MAJOR PROJECTS ASSESSMENT
DEPARTMENT OF PLANNING & INFRASTRUCTURE
GPO BOX 39
SYDNEY NSW 2001

4 May 2012

**SUBMISSION - HOMEBUSH BAY BRIDGE – PROJECT
APPLICATION MP 10_0192 Proposed public transport and
pedestrian / cycleway bridge across Homebush Bay
(Wentworth Point to Rhodes)**

Figure 4.2 – Proposed Homebush Bay Bridge in cross-section looking west

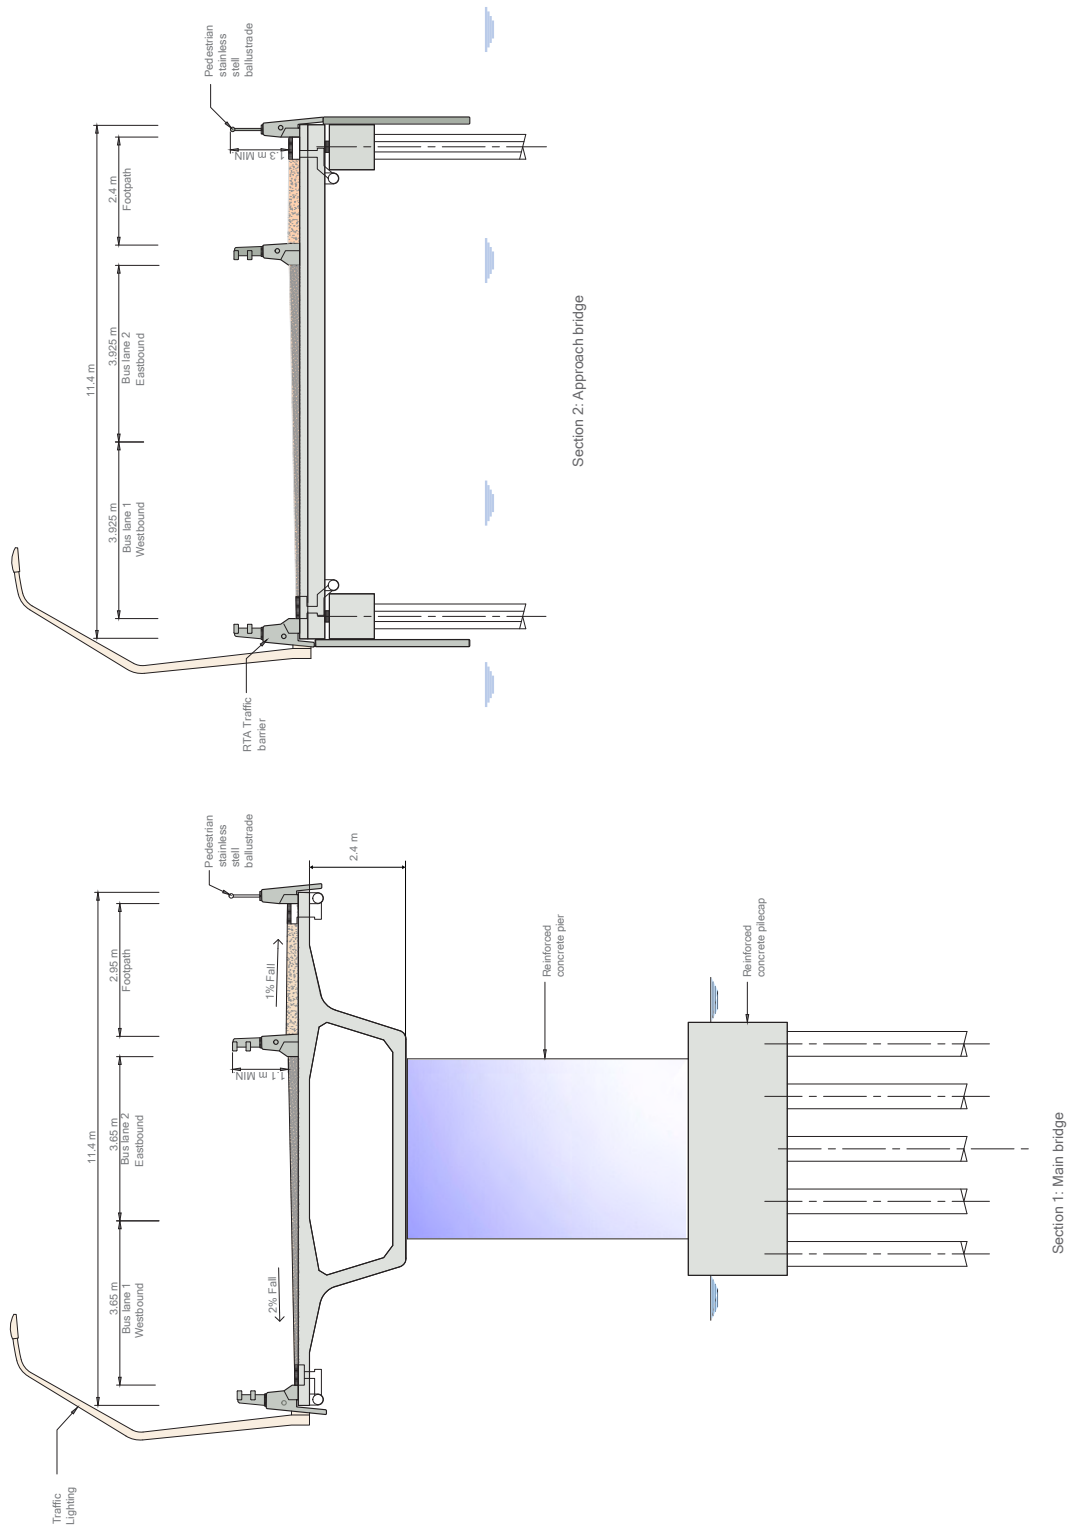
The proposed bridge cross-section does not comply with the requirements of Austroads Standards Guide to Road Design Part 3.

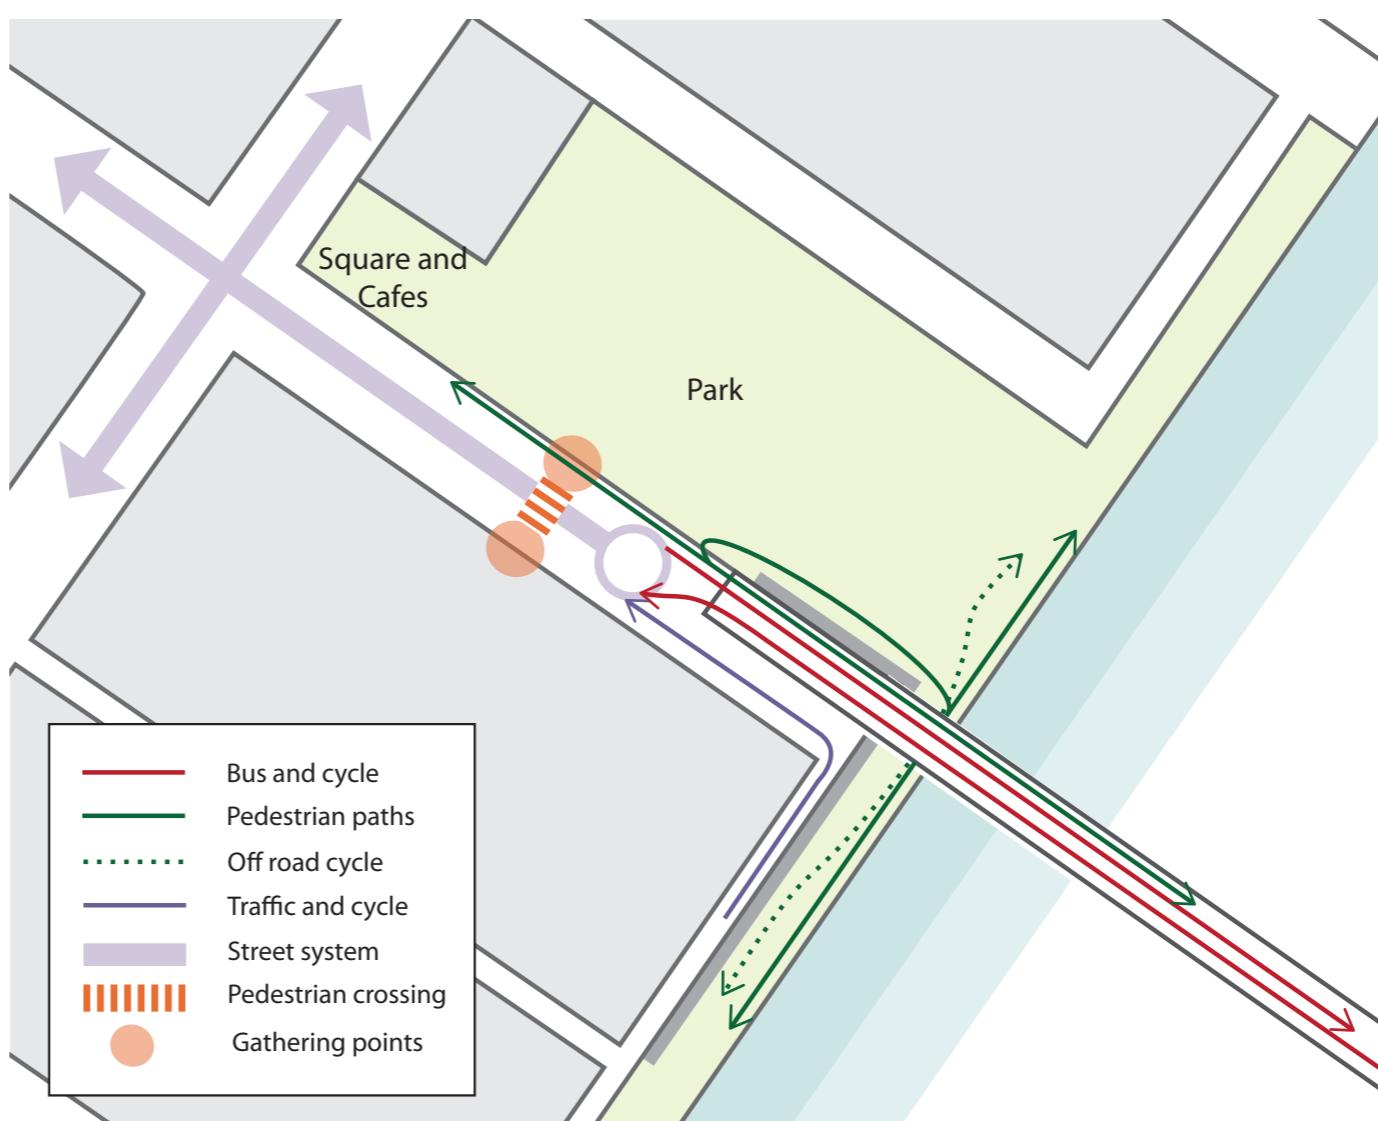
The benefits of the grade-separated landing/approach at the Wentworth Point end of the bridge are noted (i.e. safety). However there appears to be extremely poor connection, particularly for cyclists, between the Wentworth Point side Promenade and the Wentworth Point bridge approach. It is anticipated that this will be a strong desire line for both recreational and commuter cyclists. The

cycling connections between bridge approach and promenade need to be improved to both the north (via replacement of steps with a ramp, or via an addition of a ramp) and south (via a ramp through the "mass planting batter") of the bridge. These recommended improvements will also significantly improve connectivity and accessibility for people with prams, and people in wheelchairs.
